SUNNICA ENERGY FARM

EN010106

8.56 Written Summary of Applicant's Oral Submissions at the
Compulsory Acquisition Hearing (CAH) 1 on 6 December 2022

16 December 2022
Version number: 00

### **I.2                      Land and Crown Plans**

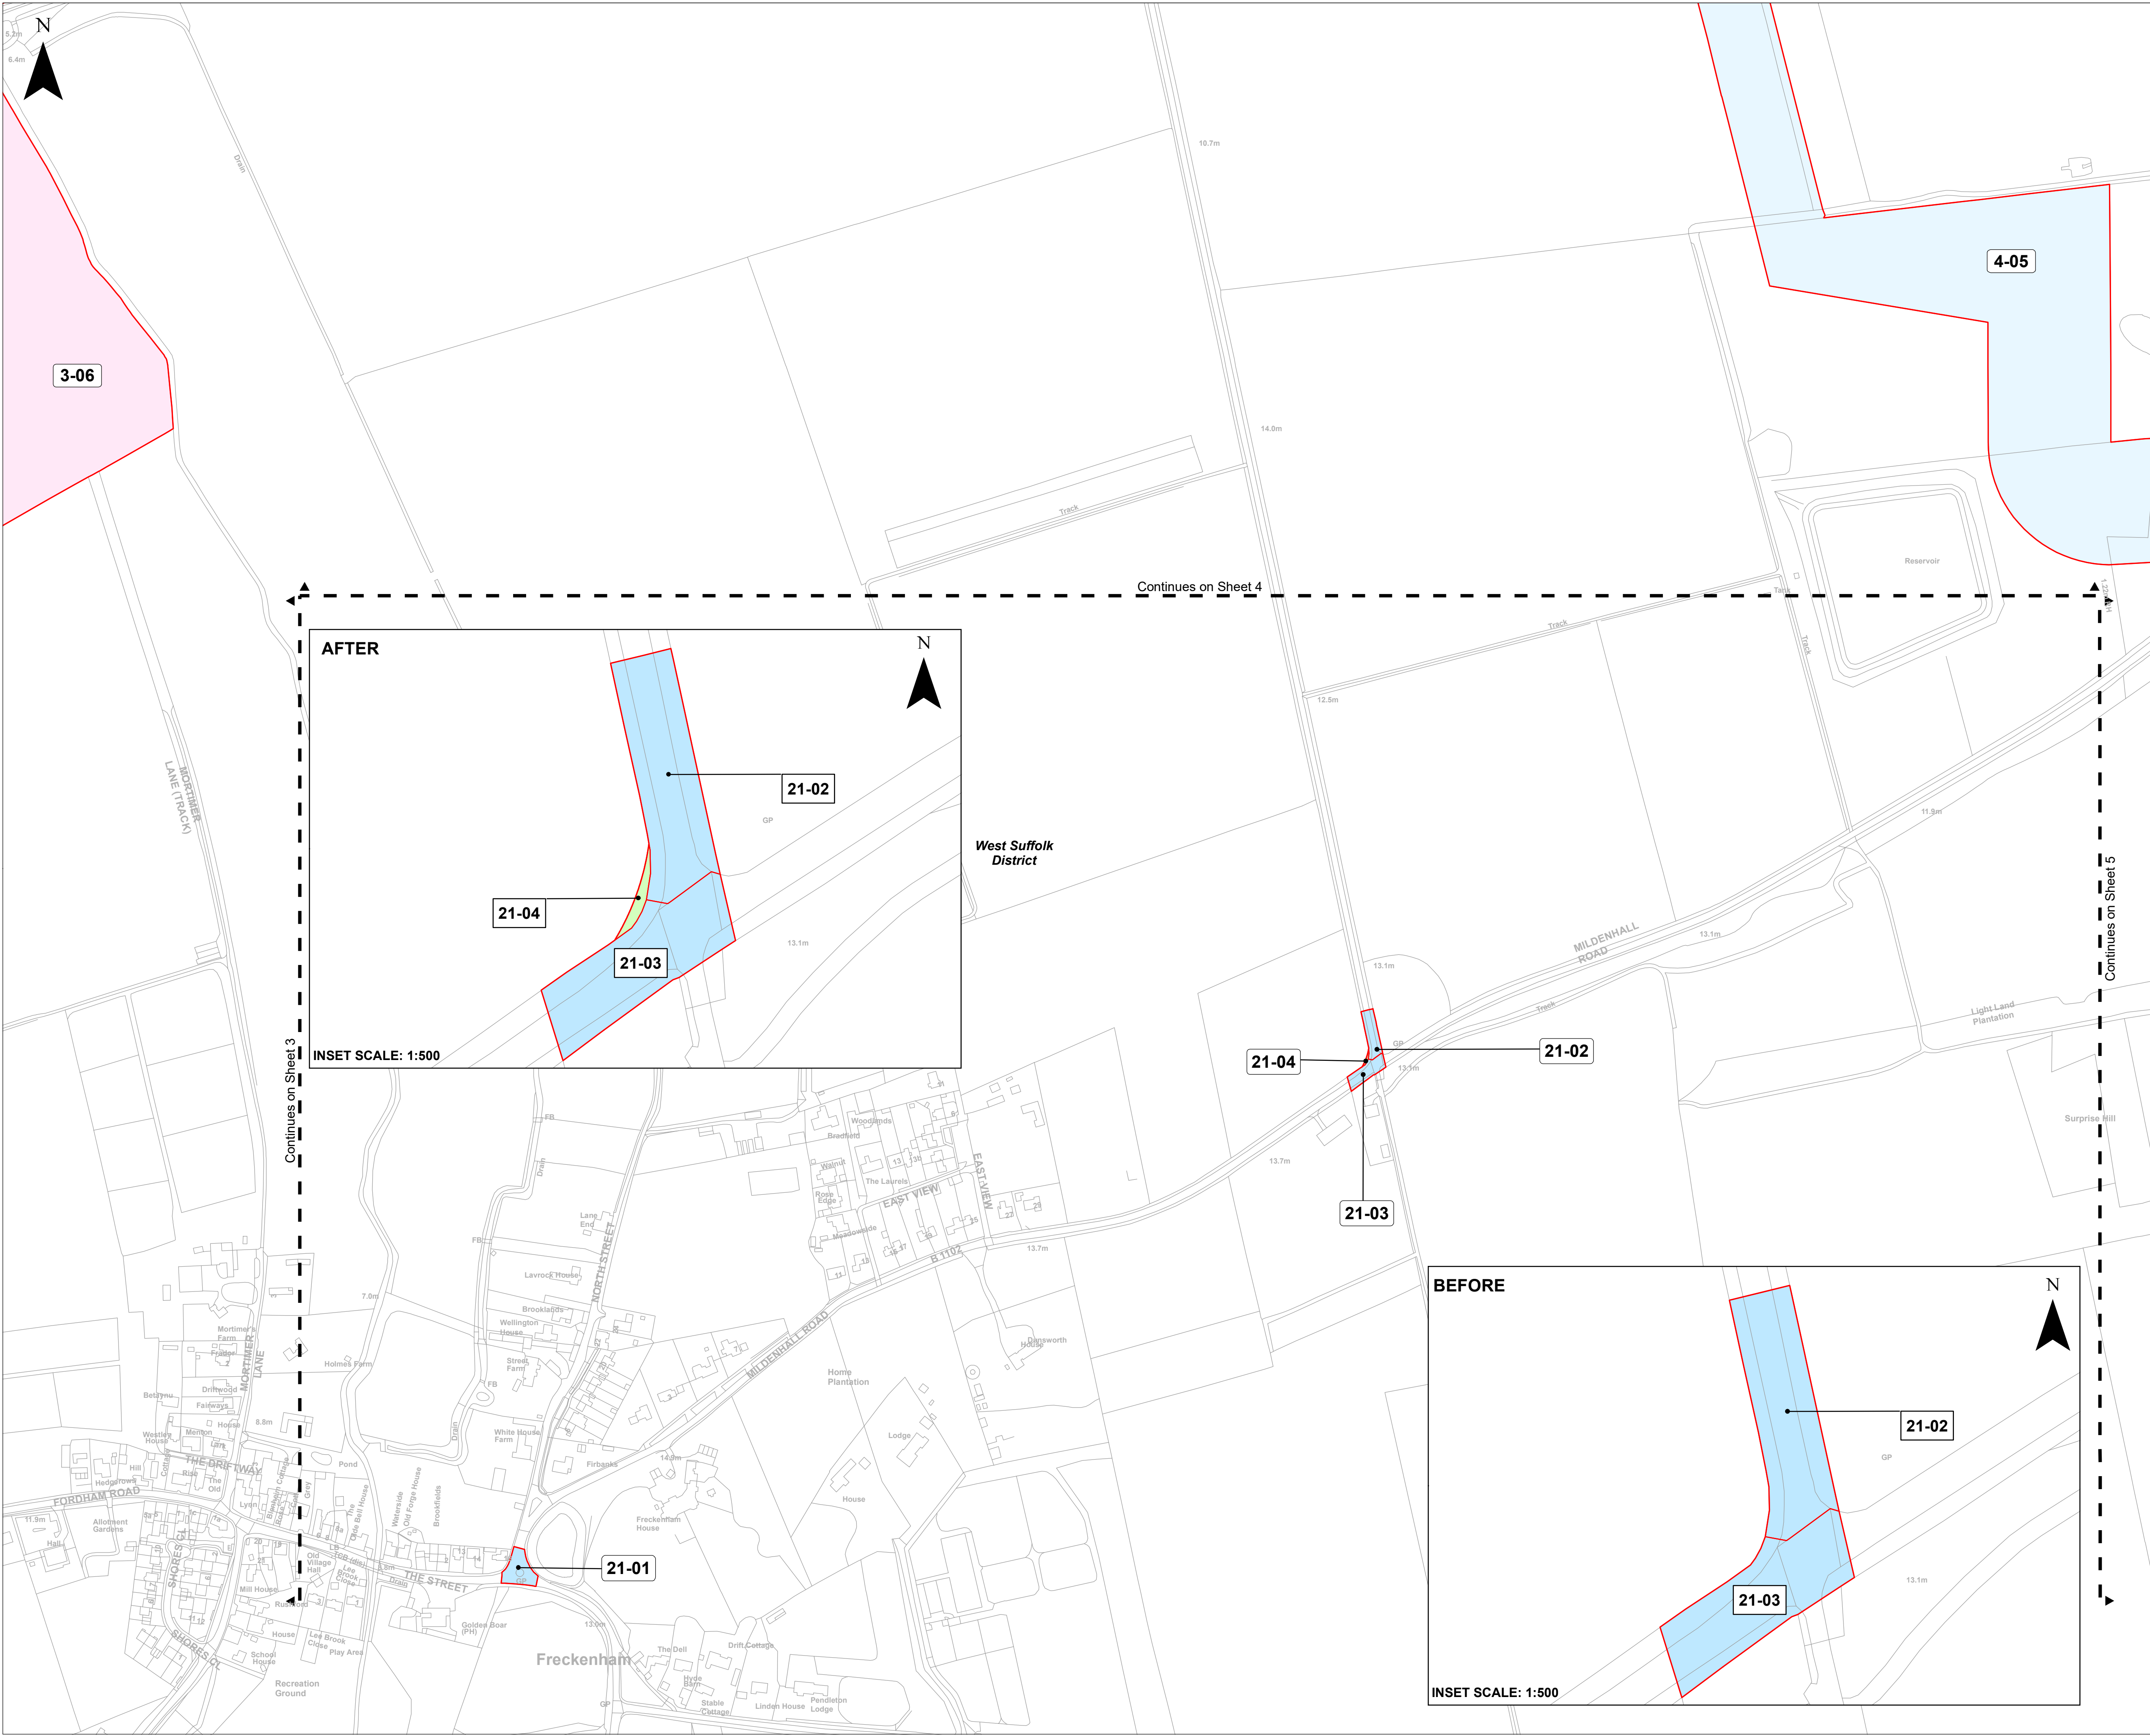
- 4.4 The ExA then made the following queries in relation to the Land Plans:
- (a) Whether the Land Plans are Rev-02 or Rev-03, as the submission titles suggest Rev-03 whereas the individual sheets suggest Rev-02.

- (b) Why the key on all sheets shows a green box even though not all sheets contain a green plot. The ExA stated that it would be useful if the green box in the key was only included on the sheets where there are green plots.

- (c) Plot 21.04 of the Land Plans is barely discernible, and a large scale inset of that plot would be useful. For example, the inset on Plot 21.04 on Rev-01.

- 4.5 Richard Turney, on behalf of the Applicant, responded to the ExA queries as follows:
- (a) Mr Turney confirmed that the Land Plans are Rev-03.
 - (b) Mr Turney said that the Applicant would look into why the sheets may potentially show an incorrect key. Mr Turney also confirmed that the green key does not show replacement land because the Scheme has no replacement land. The green key refers to the temporary use or temporary possession of land only.

- (c) Mr Turney confirmed that Plot 21.04 was the only green plot on sheet 21 but that the Applicant can provide an inset.
- 4.6 The Applicant has submitted REV-04 of the Land and Crown Plans alongside this document at Deadline 4 addressing the comments above.
